M3J9

Response to REP5-026 and -027

The applicant's documents 8.17 and 8.17.1

Winchester Action on the Climate Crisis

DRAWING TITLE
FIGURE 5.5 - AIR QUALITY: HUMAN RECEPTORS AND 2027 DO-SOMETHING NO₂ ANNUAL AVERAGE CONCENTRATION APFP REGULATIONS 5(2)(a)
SHEET 1 OF 3
DOCUMENT REFERENCE 6.2

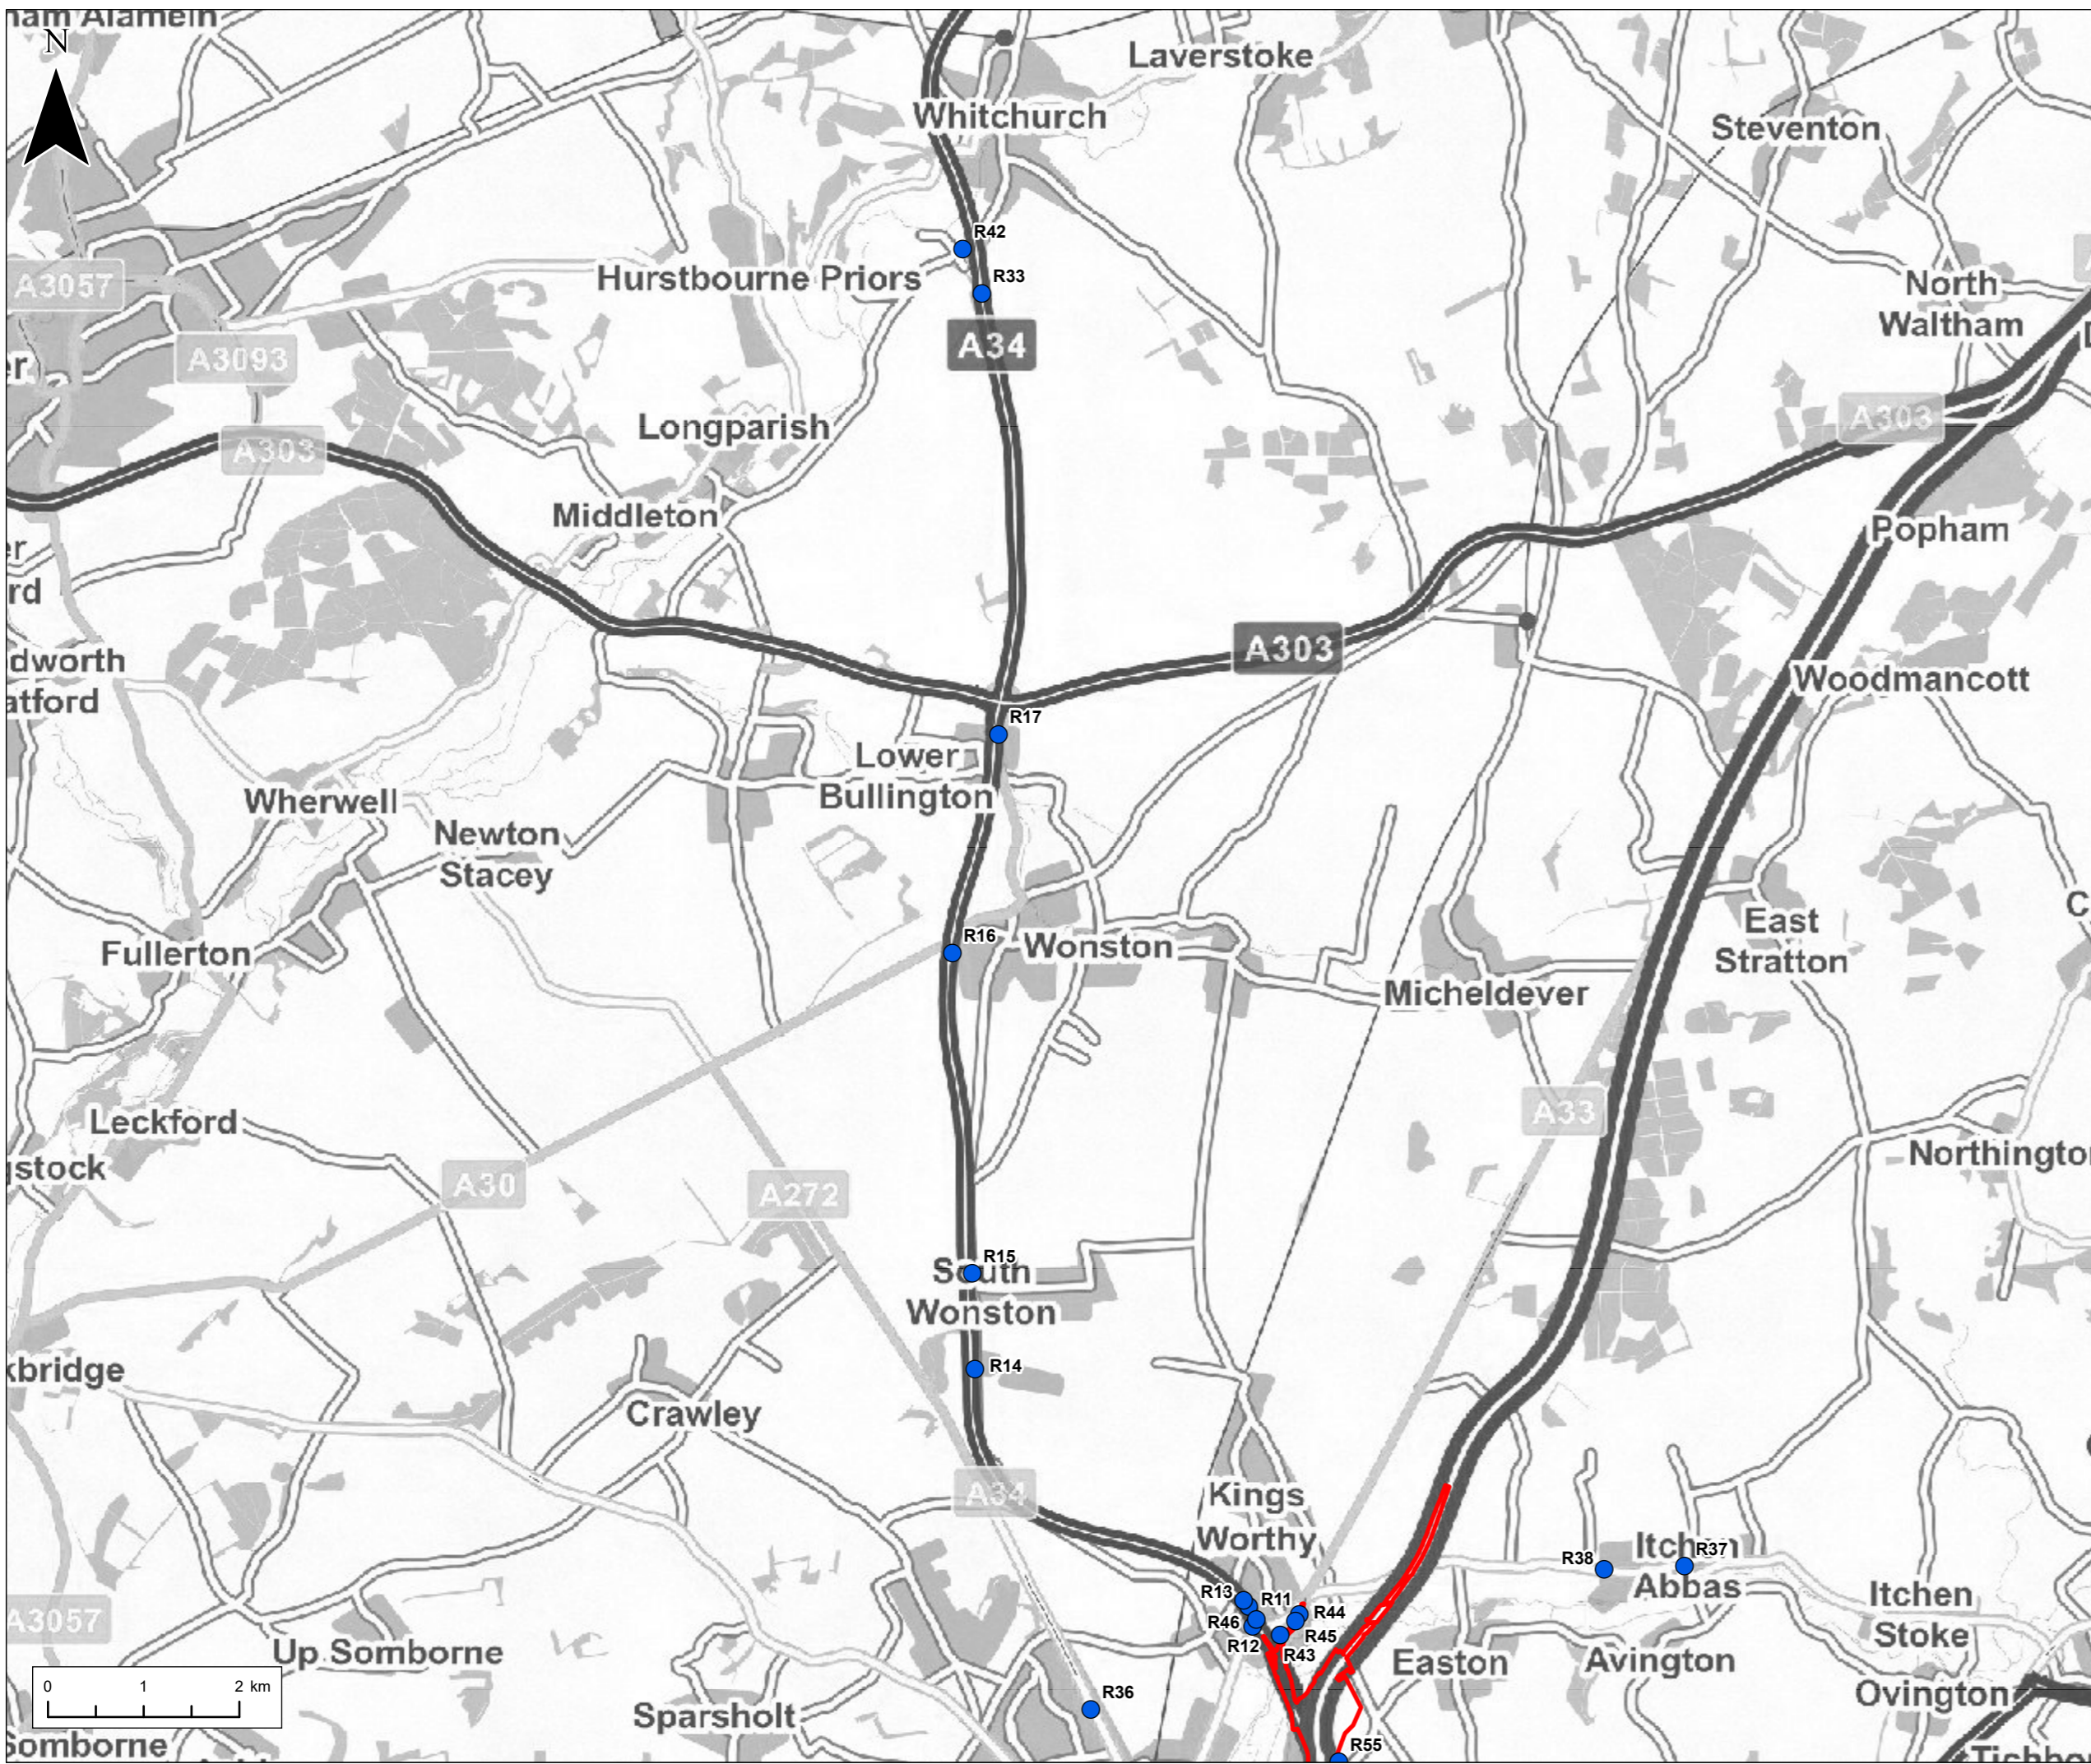
We still feel that a map similar to the one shown in the PEIR would have offered greater transparency, and demonstrated more clearly how the roads constructed in the scheme will supplement background levels of PM_{2.5}. We need the applicant to provide more clarity on how excessive levels of PM_{2.5} will coincide with the location of the roads they propose to construct.

Table 1.4 of Appendix 5.2 (Human Receptors Backgrounds and Operational Phase Results) of the ES (6.3, APP-086) may be more precise about the levels of PM_{2.5}, but without a key to the location of the receptors it provides no information about the spatial distribution of PM_{2.5}. It is difficult to dismiss the impression that the applicant is wanting to conceal the extent and nature of PM_{2.5} pollution the proposal will cause.

At some receptors, according to appendix 5.2, pollution will be above thresholds and DS will be higher than DM in 2027, but the applicant has not told us how the changes will correspond with proposed changes in road layout and there is no map of this to help us.
